**Wattle Creek Solar Farm (SSD-63344210) and Wattle Creek BESS (SSD-63345458) projects.**

### **Informal Feedback from Wingecarribee Shire Council**

Figure 06 – Land Zoning
Basemap Source: ESRI, 2024

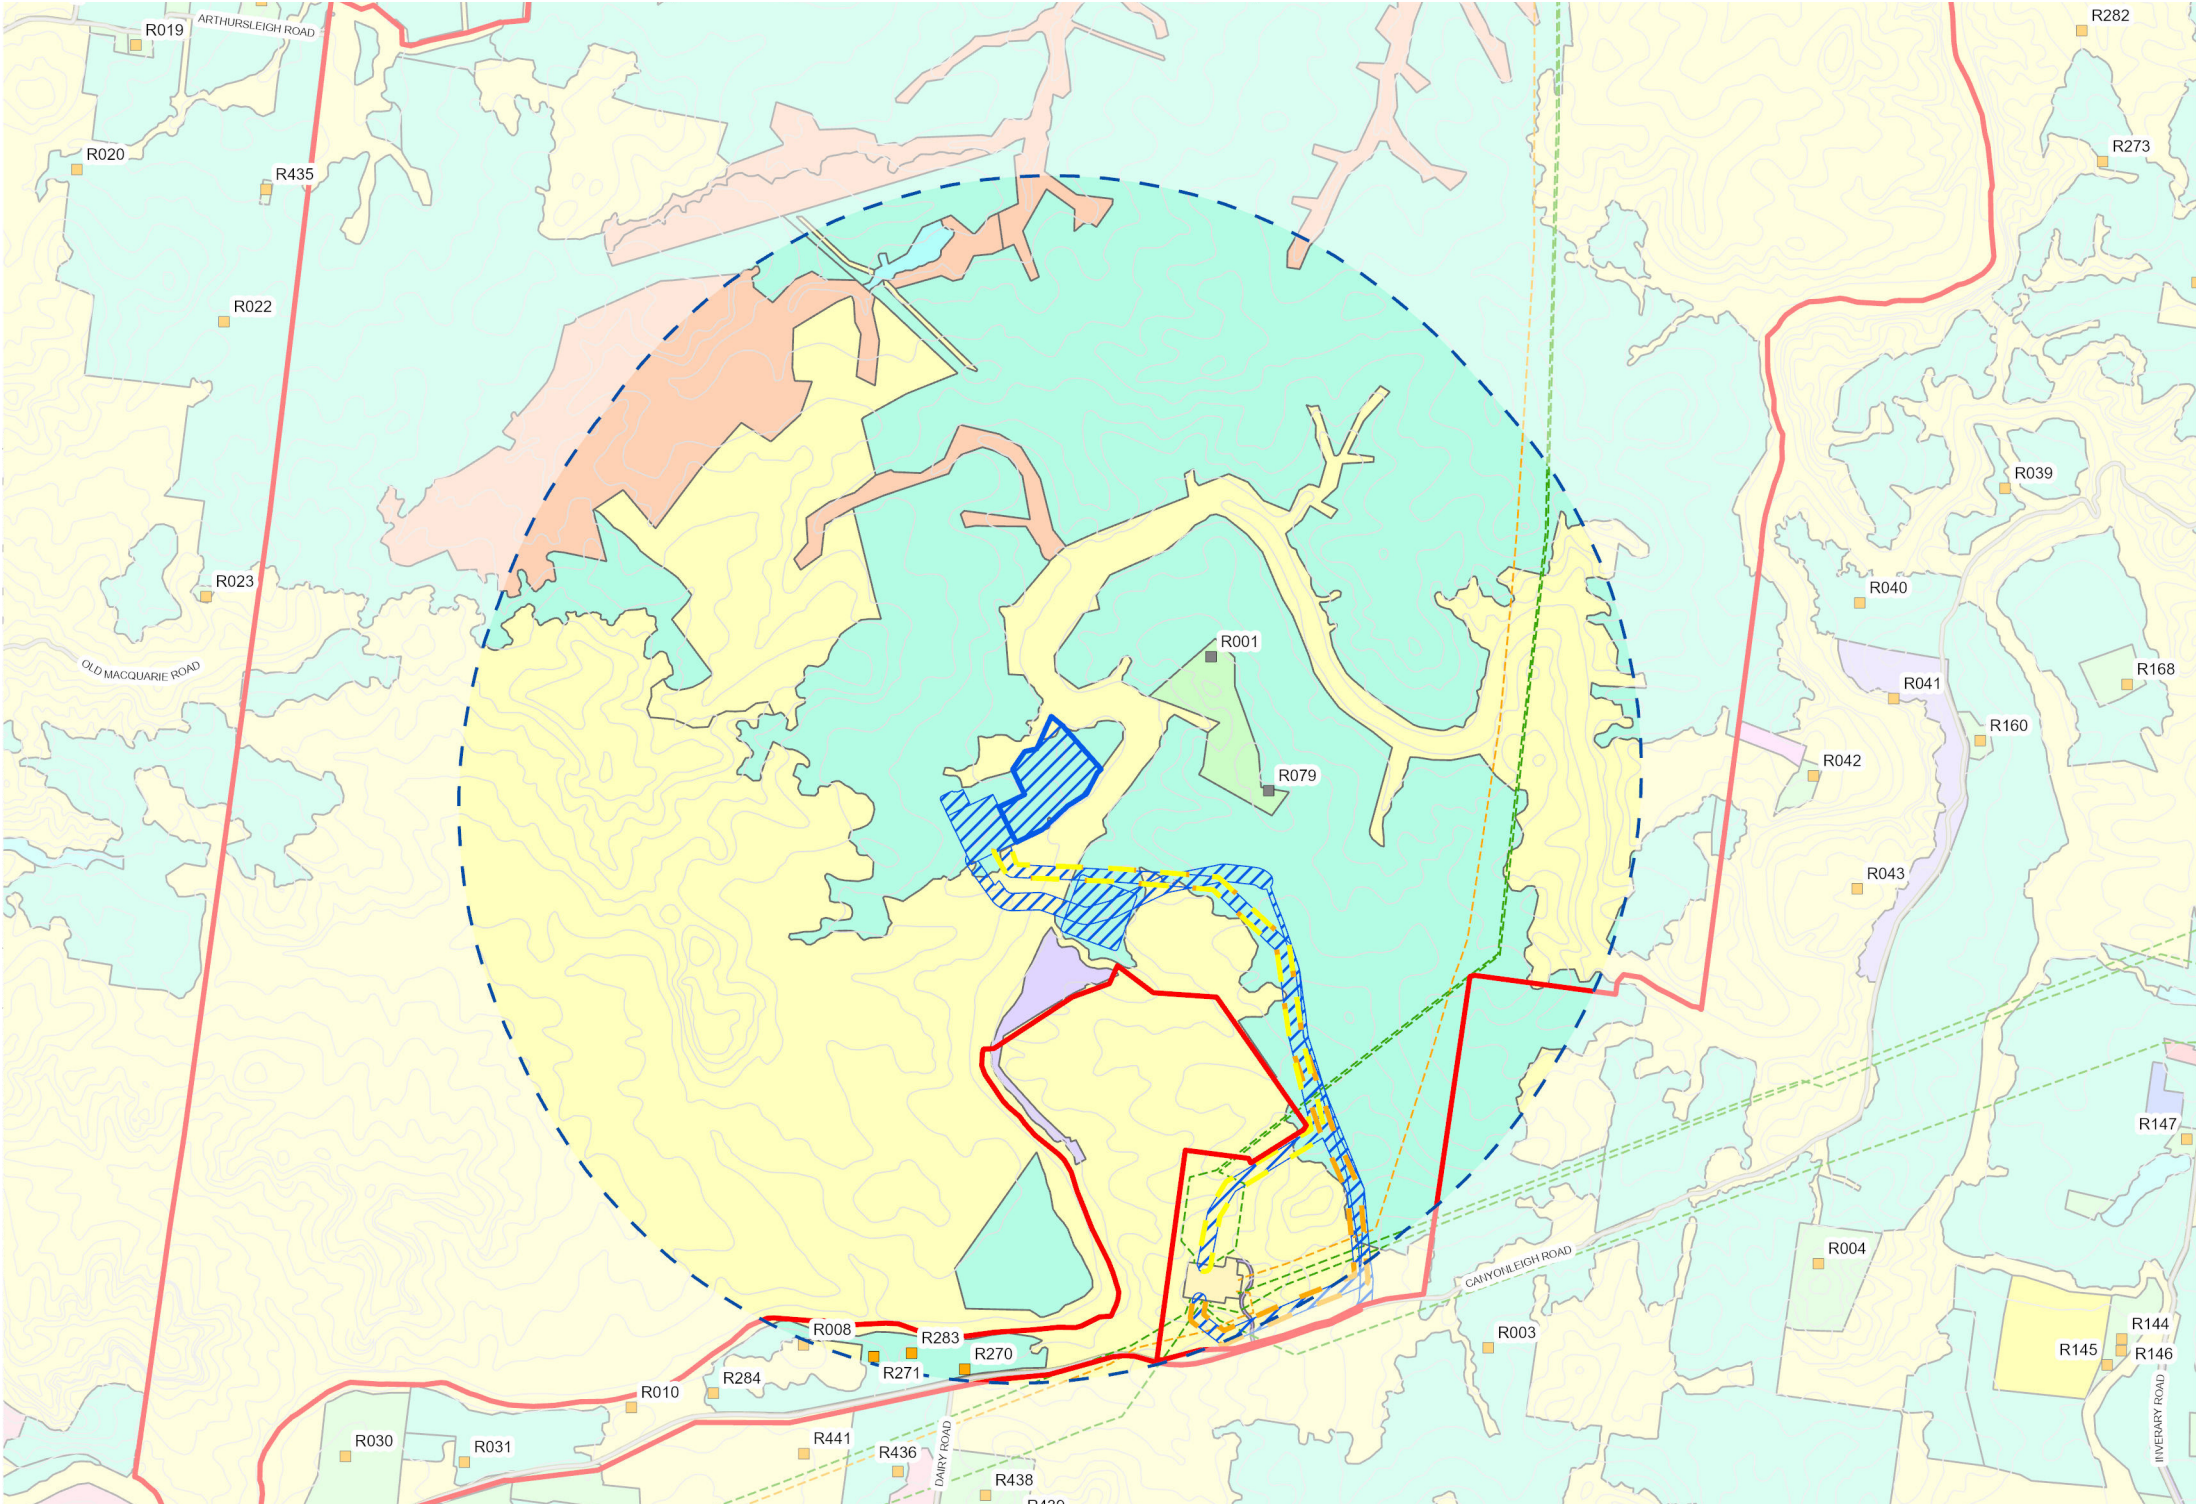
These elevated zones fall outside the 5 km field assessment but are within the theoretical Zone of Visual Influence (ZVI) shown in Figures 6, 13, 14, 23, 24, 26 of the document as denoted by the blue and purple shading across substantial portions of eastern land in Wingecarribee Shire.

Council requests that the proponent undertake an expanded LVIA, or a supplementary visual assessment, that includes elevated view-sensitive areas within Wingecarribee Shire east of the project site.

- The addition of new photomontages or visual simulations from key elevated locations within the Wingecarribee Shire.
- Consideration of the cumulative long-range impacts on landscape character from the regional perspective.
- Engagement with affected Wingecarribee residents in future consultation or design refinement.
- Further consideration of the management of proposed transport routes.
